Application Ref:	3/2019/0677	 Ribble Valley Borough Council www.ribblevalley.gov.uk
Date Inspected:	28/08/2019	
Officer:	RB	
DELEGATED ITEM FILE REPORT:		APPROVAL

Development Description:	Single storey extension to rear
Site Address/Location:	Falcon Cottage, Fleet Street Lane, Ribchester, PR3 3YR

proposed elevations

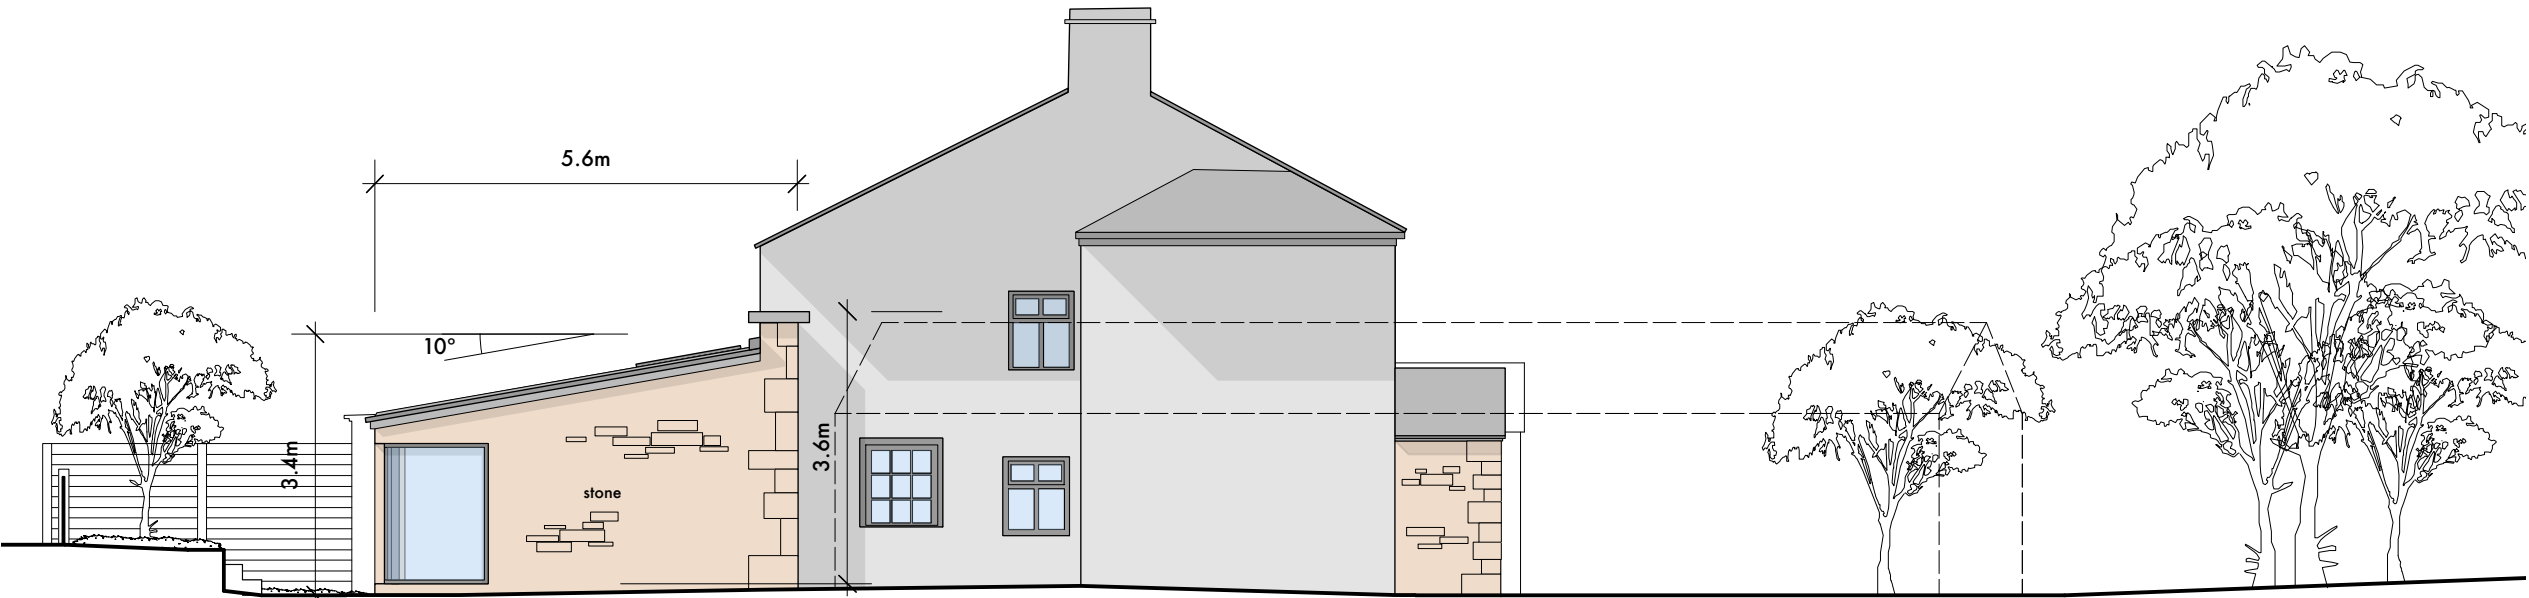
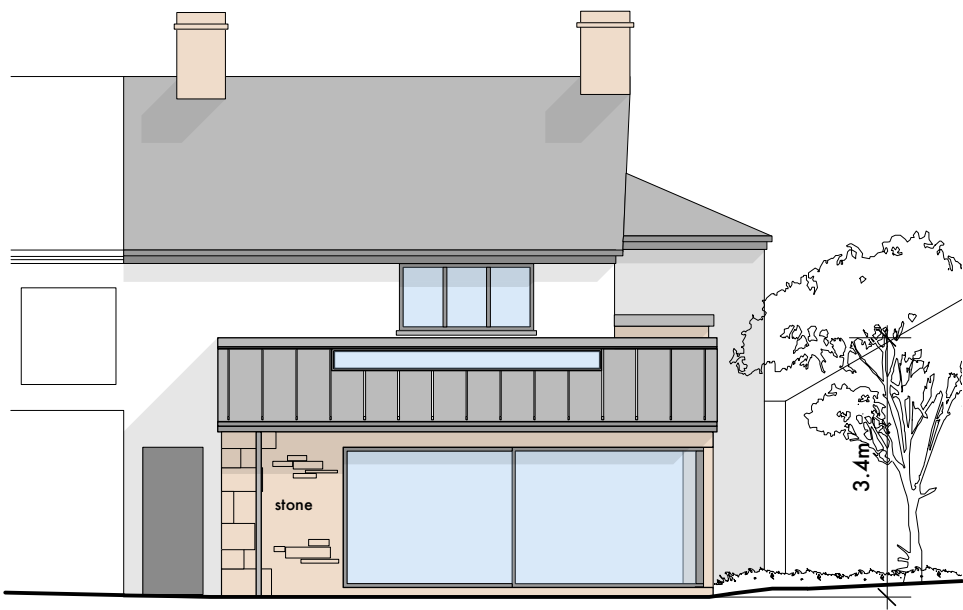
The proposed extension will be larger than the existing rear lean to however as the adjacent property to the north, Falicon Farm has a similar projecting element to the rear that appears to be a store/garage and the window serving this room is not a habitable room as well as being obscurely glazed it is considered that the development will have minimal impact on the residential amenity of this property.

The property to the south is Falicon Bungalow. This property will also be unaffected by the proposed development due to the scale and position of the development. The development proposes a window facing into the garden area of Falicon Bungalow however it is considered that the existing boundary treatment will provide a screen meaning that the window would not result in the overlooking of this property. Therefore it is considered that the proposed extension will have minimal impact on the residential amenity of this property in terms of loss of light or privacy.

The existing dwelling is of a modest size constructed using stone and render. The proposed extension will be constructed using stone with a grey zinc roof and the windows will have an aluminium frame. While the use of zinc is not common within the locality, due to the extension being to the rear of the dwelling it is considered that the proposed materials will not negatively impact the visual amenity or character of the area.
